**OS Parcel 9100 Adjoining And East Of Last
House Adjoining And North Of Berry Hill Road
Adderbury**

23/00495/DISC

Proposal: Discharge of Conditions 8 (fencing and gate details - LAP play area), 10 (revised landscaping plans) of 22/00959/REM

scheme: Land off Berry Hill Road,
Alderbury, Banbury
client: Hayfield Homes
drawing: Landscape Proposals
date: March 2022
scale: 1:200@A1
drawing no: HAY23648-11E Sheet 2 of 3
drawn: SR checked: JC

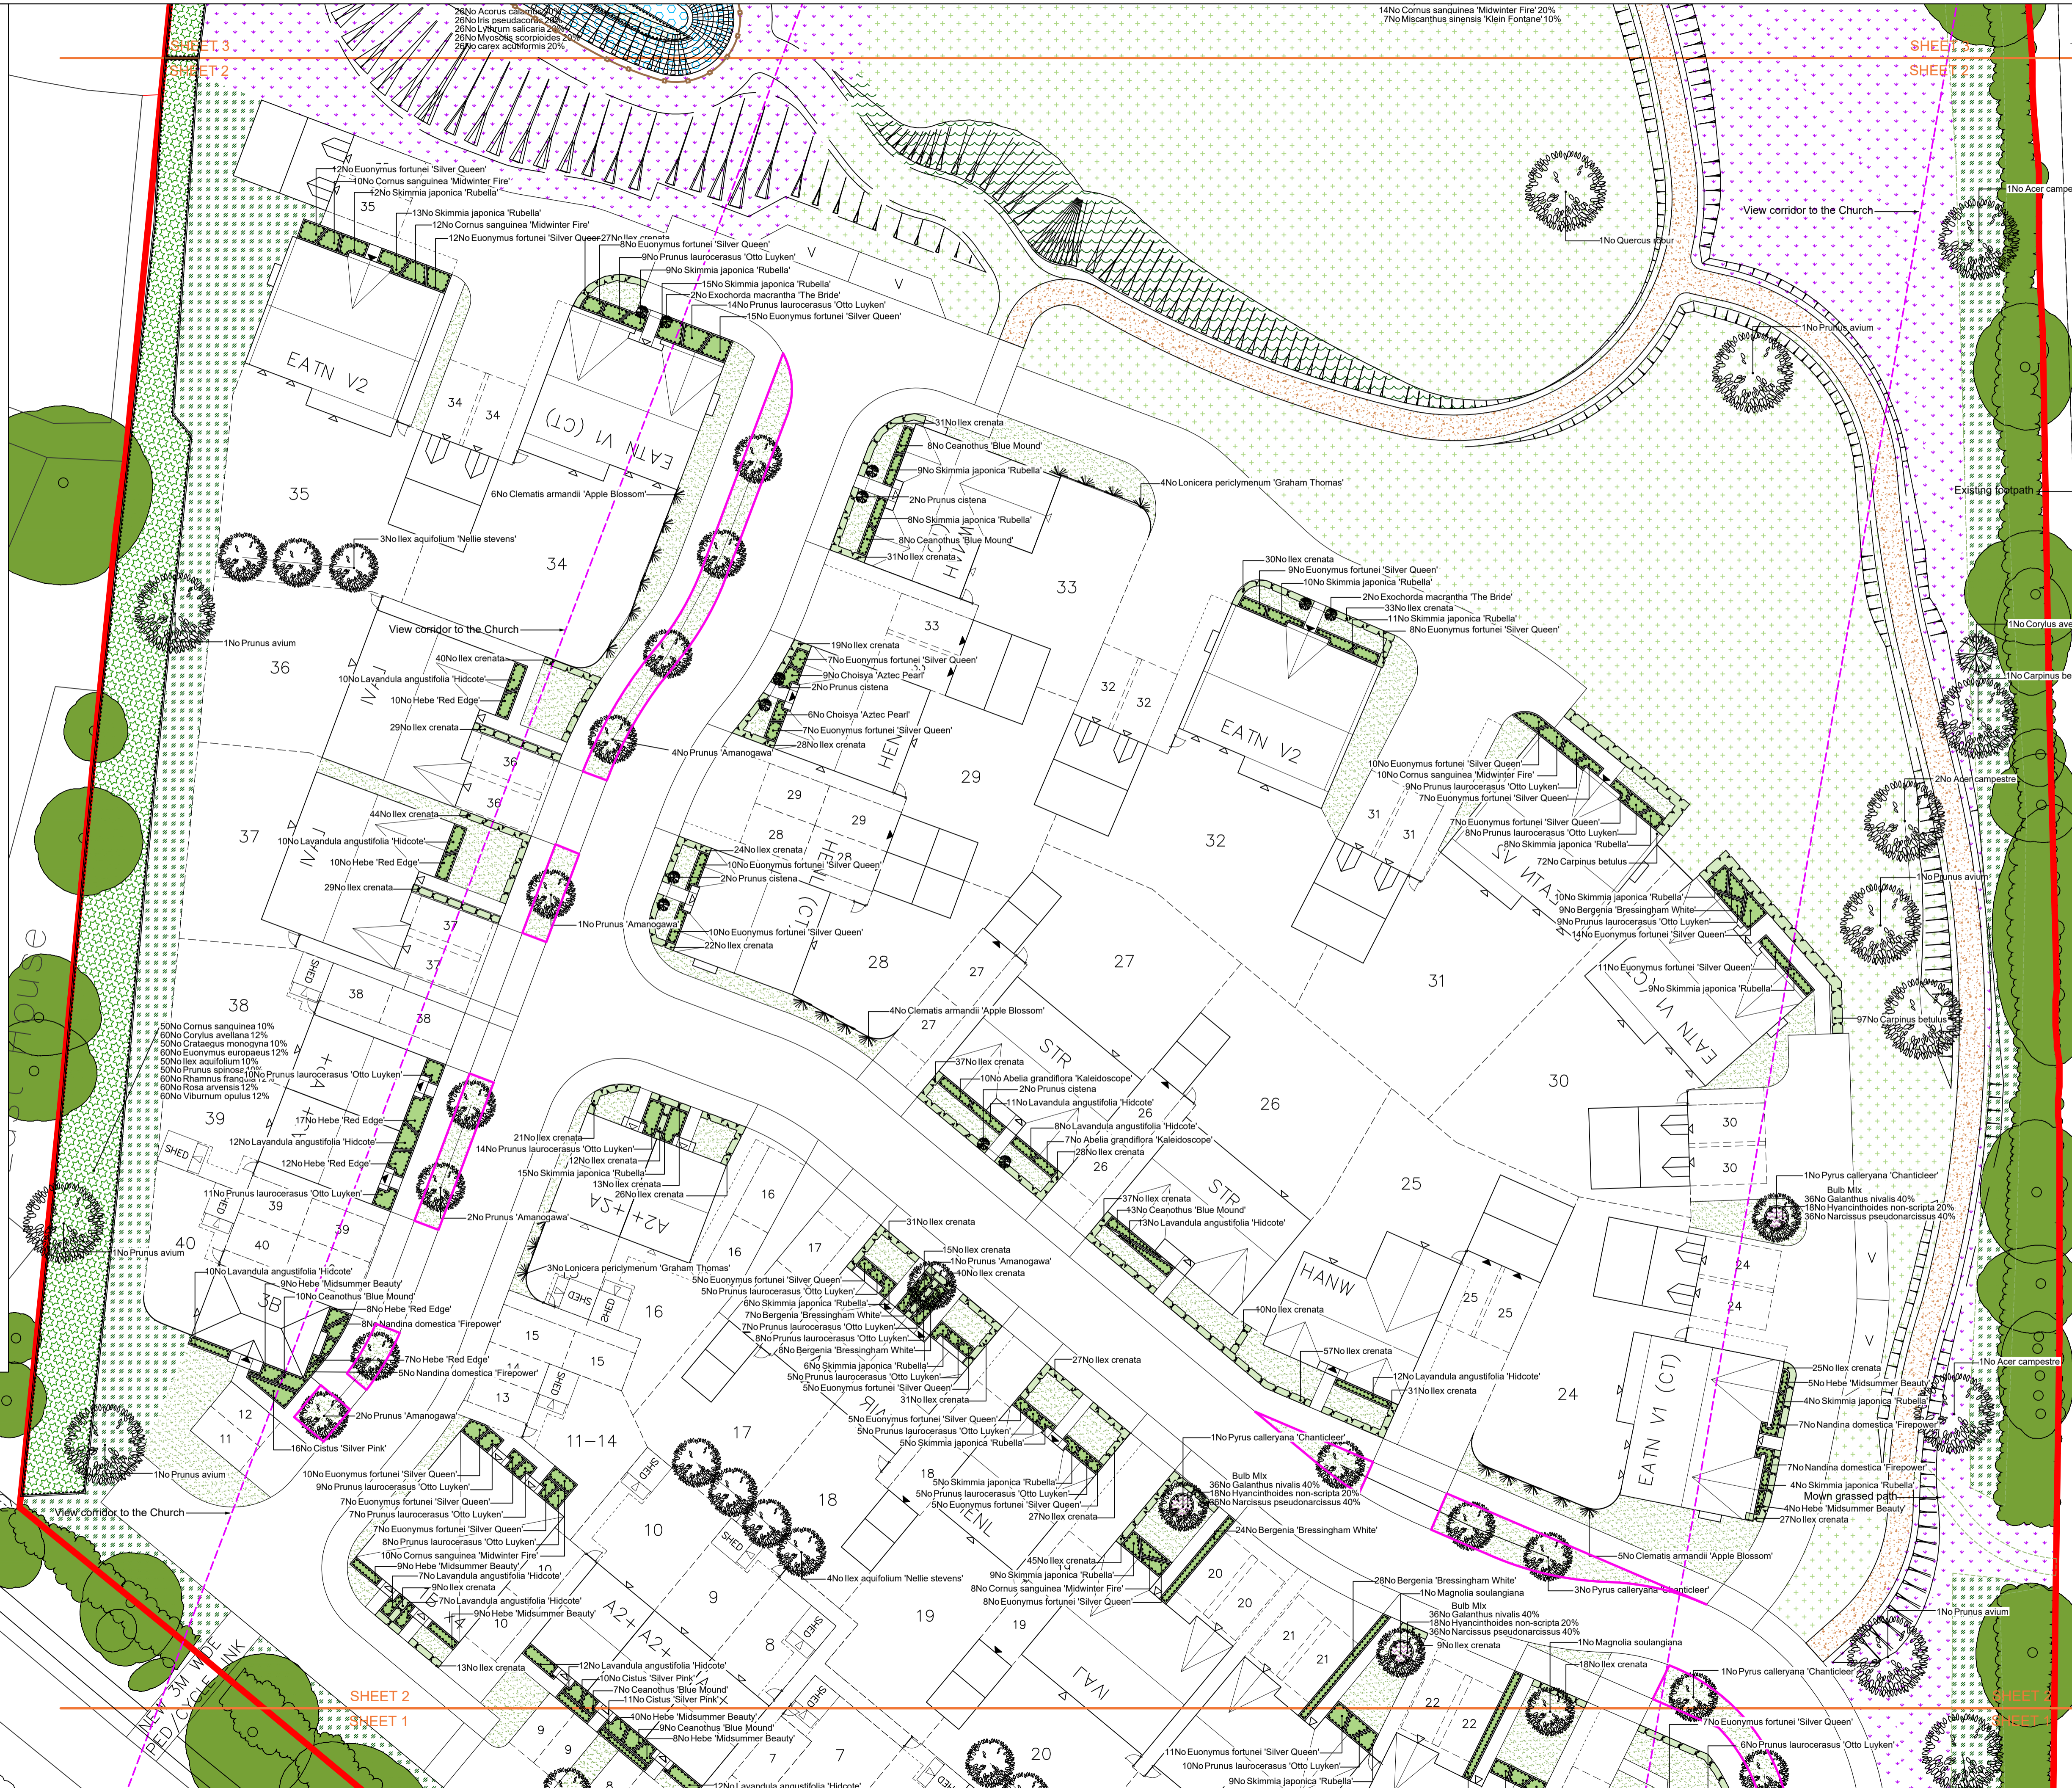
- The signage and access gate arrangements for the LAP are now acceptable. Refer to LAP Proposals HAY23648.
- The surveillance of the LAP will be improved due to the removal of the two Prunus trees. I find acceptable the relocated Prunus to the north of the play area.

- It is appropriate due to the semi-rural character of the play area that the trees within it should be native. I note that the Birch have a high pollen count with may impact on the health of children that suffer from allergies. I suggest 3 Acer campestre (Field Maple) as replacements.

- Pleased to see the removal of the toxic Euonymus fortune 'Emerald Gaiety' in favour of the Miscanthus sinensis 'Klein Fontane'.
- The seats and the litter bins are acceptable.

- The knee rail that is recommended for the wildflower meadow is not drawn on the landscape proposals.
- It will be difficult to monitor the success of the additional tree planting for privacy in the rear gardens due to insufficient council resources.
